vii. Building Heights

DRAWING TITLE:
Site Layout Plan

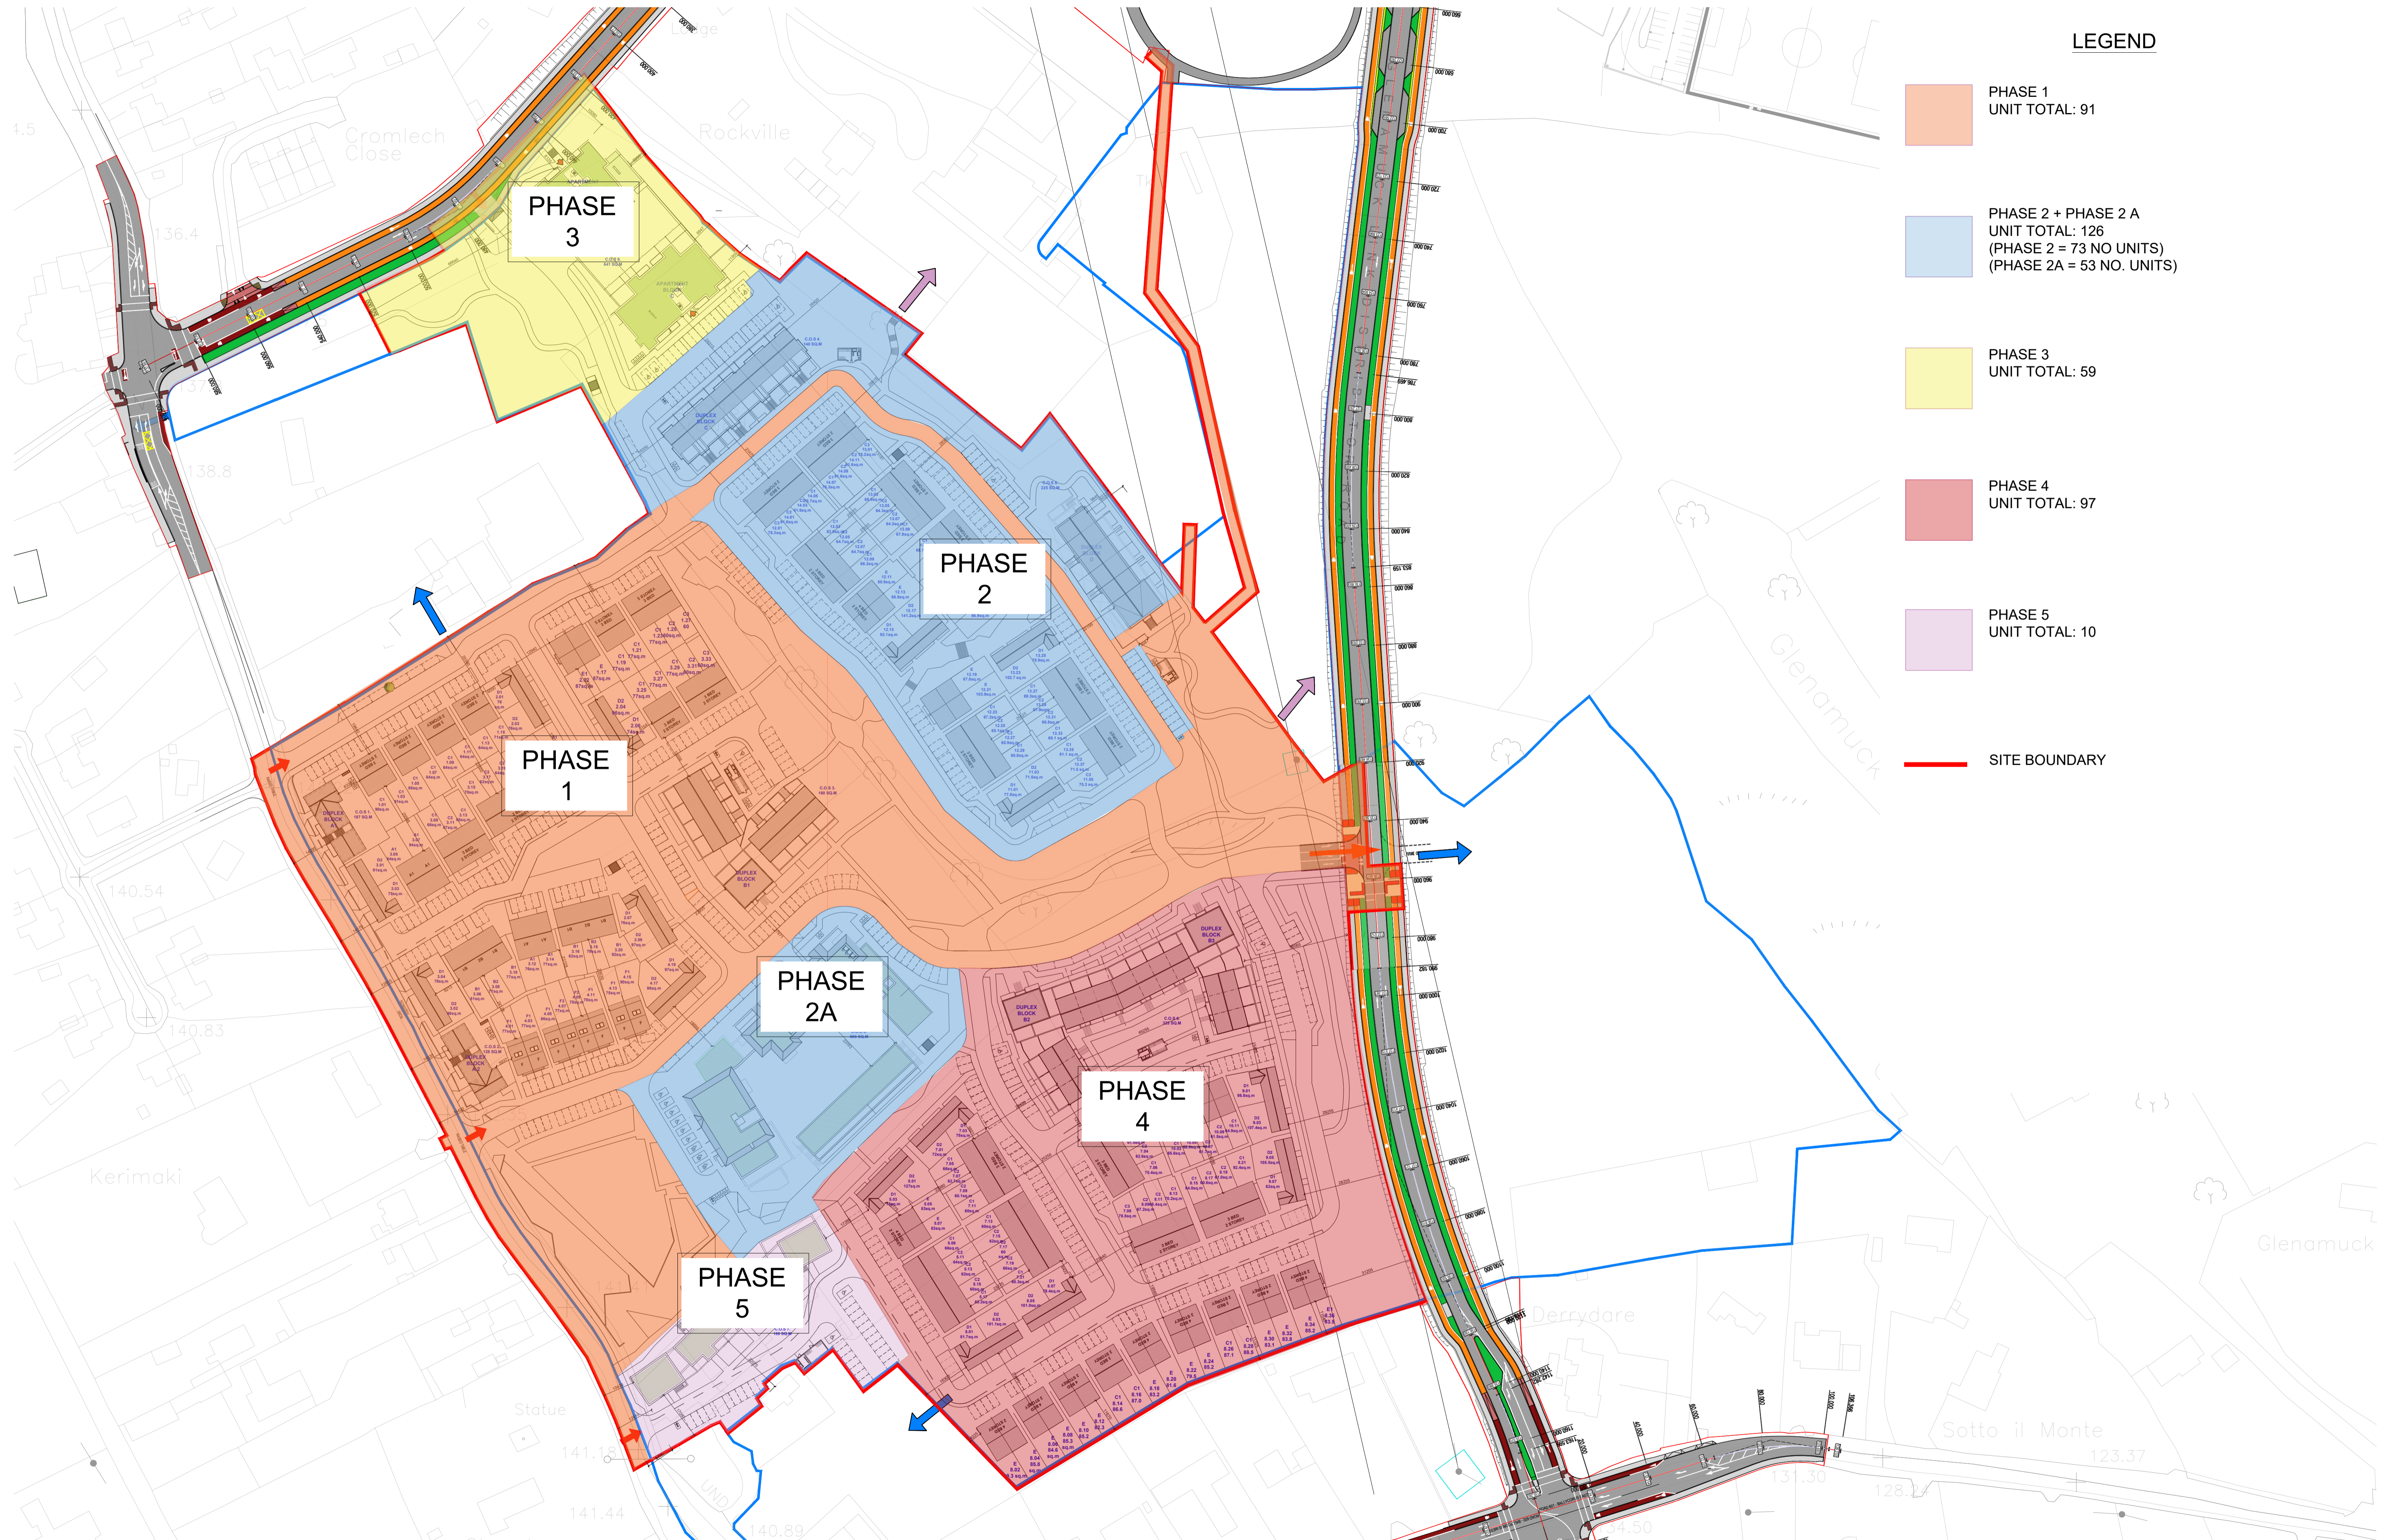
The phasing strategy proposed is noted. The Applicant should consider revisiting the strategy with a view to deliver the Neighbourhood Centre on Phase 1 as well as delivering pedestrian and cycle connections to Glenamuck Road and to the GLDR; including associated taking in charge and wayleave agreements. The reason behind this lies in that the Neighbourhood Centre would provide services that are key not only for the future residents of the proposed development but also for the wider community in Kiltiernan. These services should be accessible by active transport means as a priority of Phase 1.

RESPONSE: The Neighbourhood Centre is proposed in phase 2A i.e post the construction of 97 no. units of phase 1. This is to ensure economic viability of the Neighbourhood centre and a reasonable quantum of housing will be provided before commencement of the Neighbourhood centre.

The connection to the GLDR is proposed in phase 1 with the junction connection to be constructed upon completion of the GLDR. The Glenamuck Road connection is proposed in phase 3 as part of the overall construction of this phase.

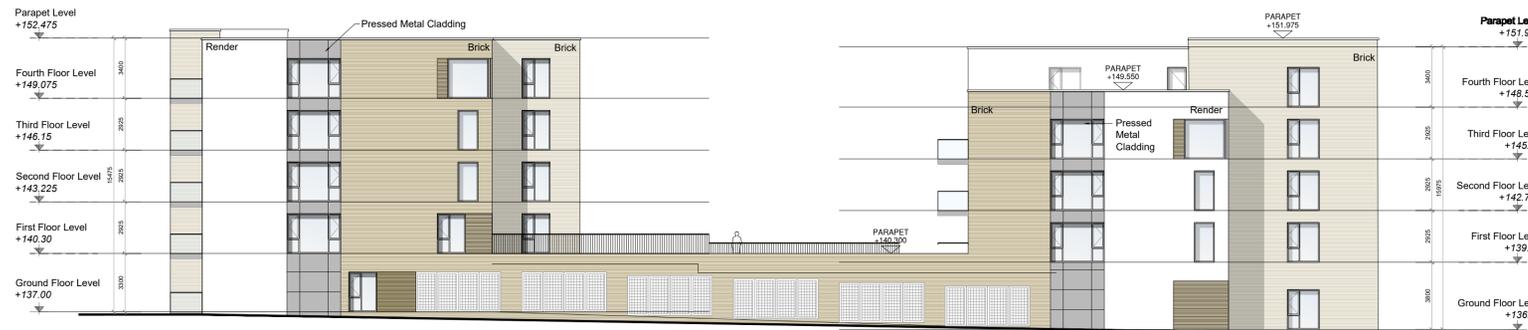
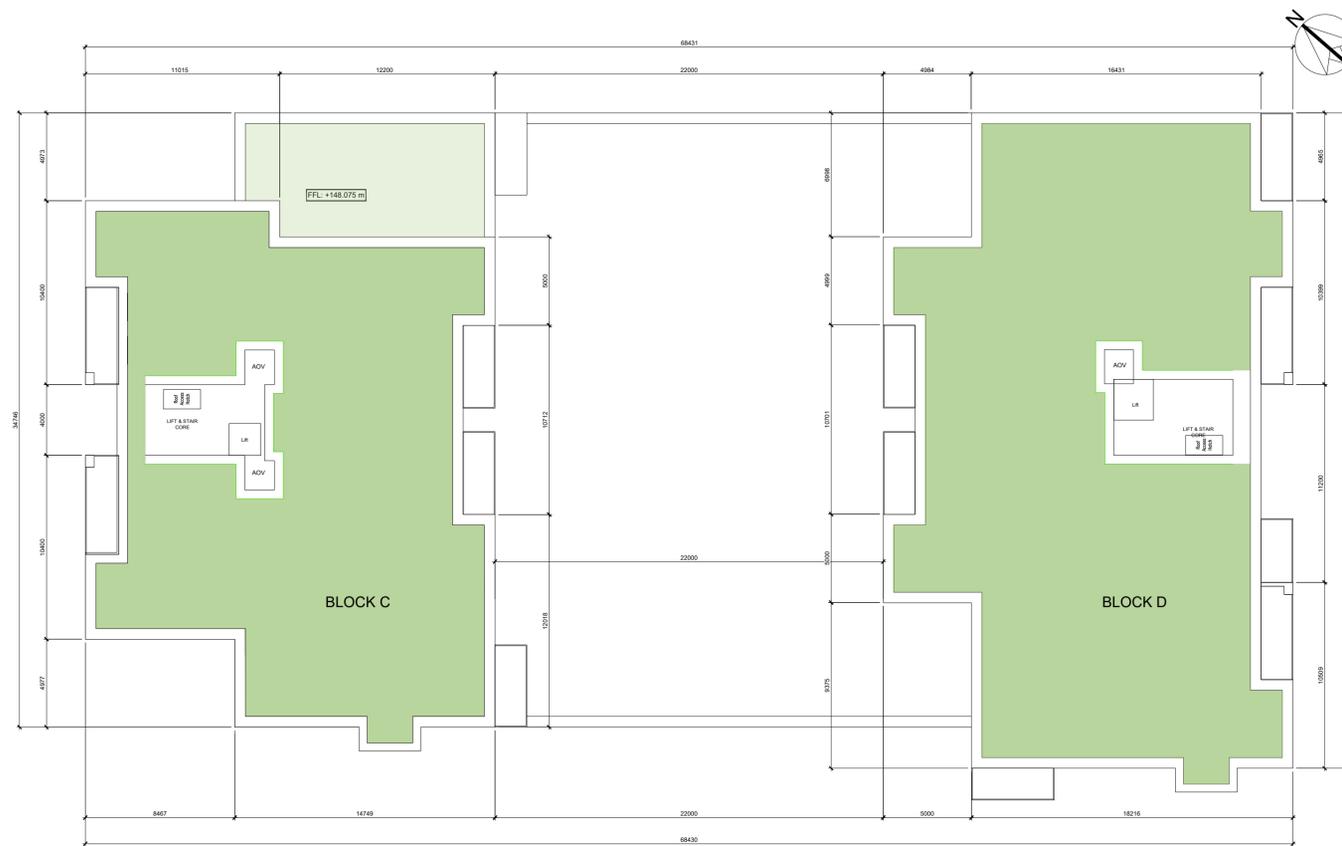
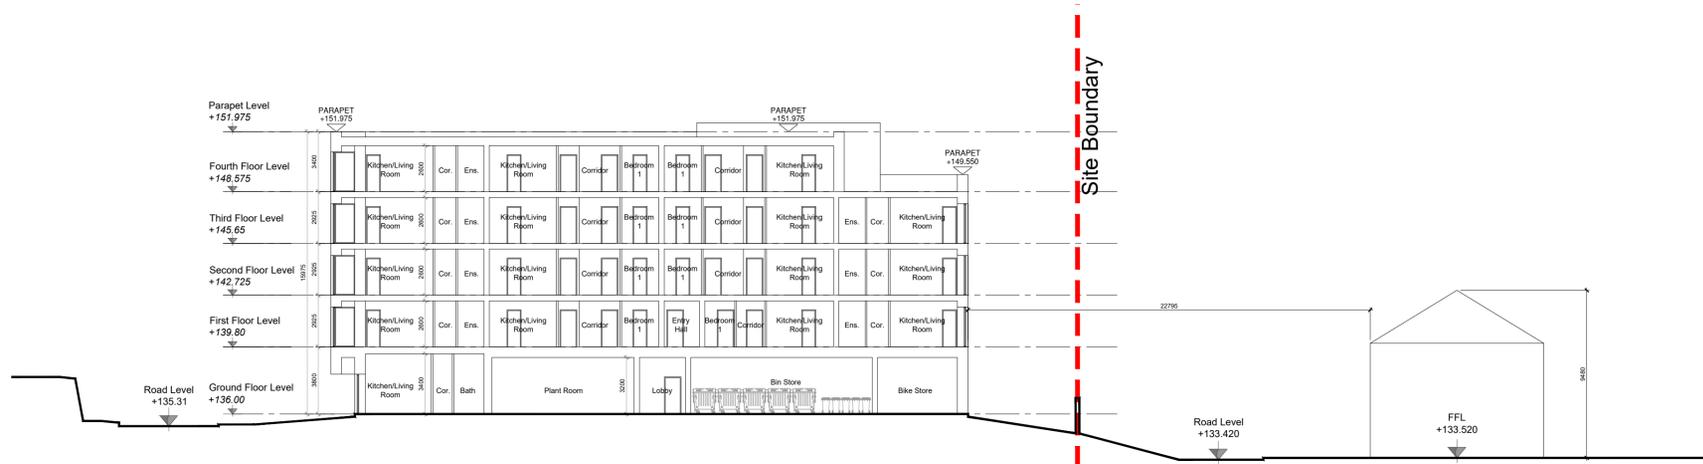
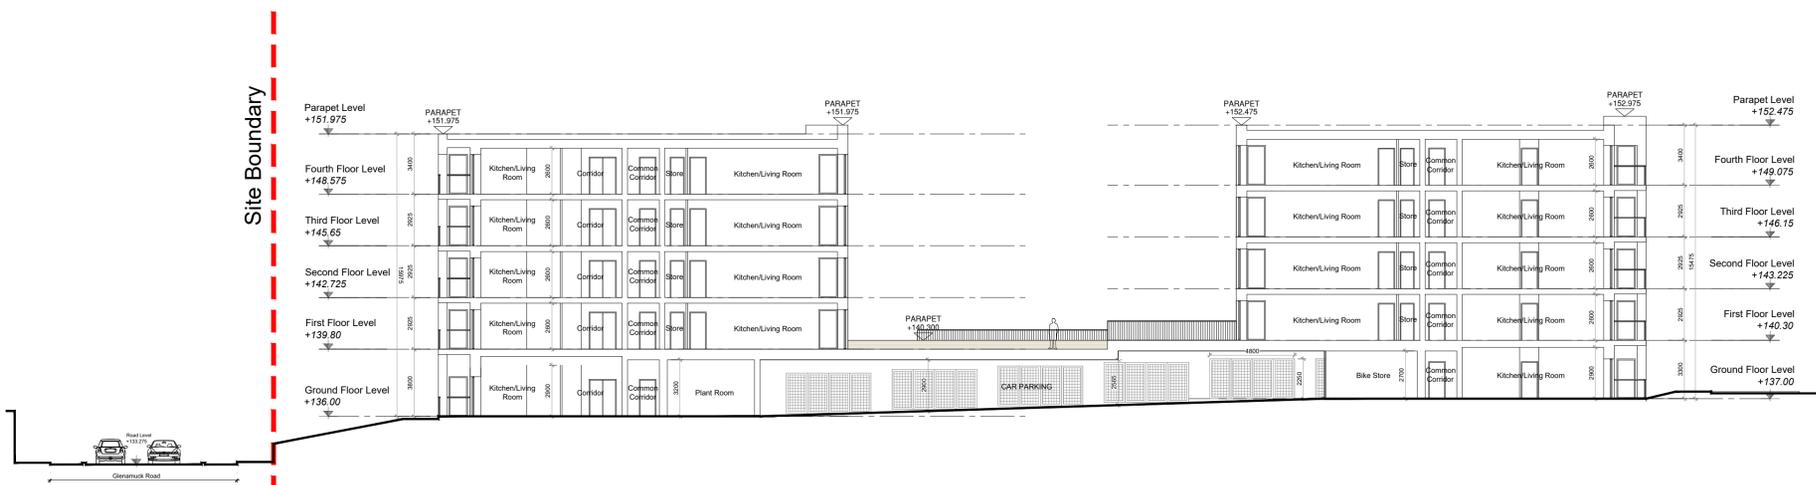
A maximum of 4 storeys is established by the LAP as maximum height for this site. The proposed Apartment Blocks C and D to the north-east of the site rise to 5 No. storeys including podium level. The proposal, therefore, does not accord with the provisions of the Local Area Plan. However, given that the deviation of the LAP parameters in terms of height is only of 1 additional storey, it is considered that the Applicant is in a position to make a strong case on the basis of the Urban Development and Building Height Guidelines 2020. In that regard the Applicant is advised to provide detailed elevations and sections drawings showing the relationship of the proposed blocks with surrounding existing and proposed structures and also a set of photomontages (which should include winter views) illustrating what the visual impact of the proposed development would be.

RESPONSE: MCORM have provided elevations and sections herby illustrating the appropriate nature of the 5 storey design proposed. In addition CGI's and a detailed Sunlight/ Daylight analysis by 3D design bureau have been included as part of this application. The detailed studies illustrate the full extent of compliance with the relevant BRE guidelines for this proposal.
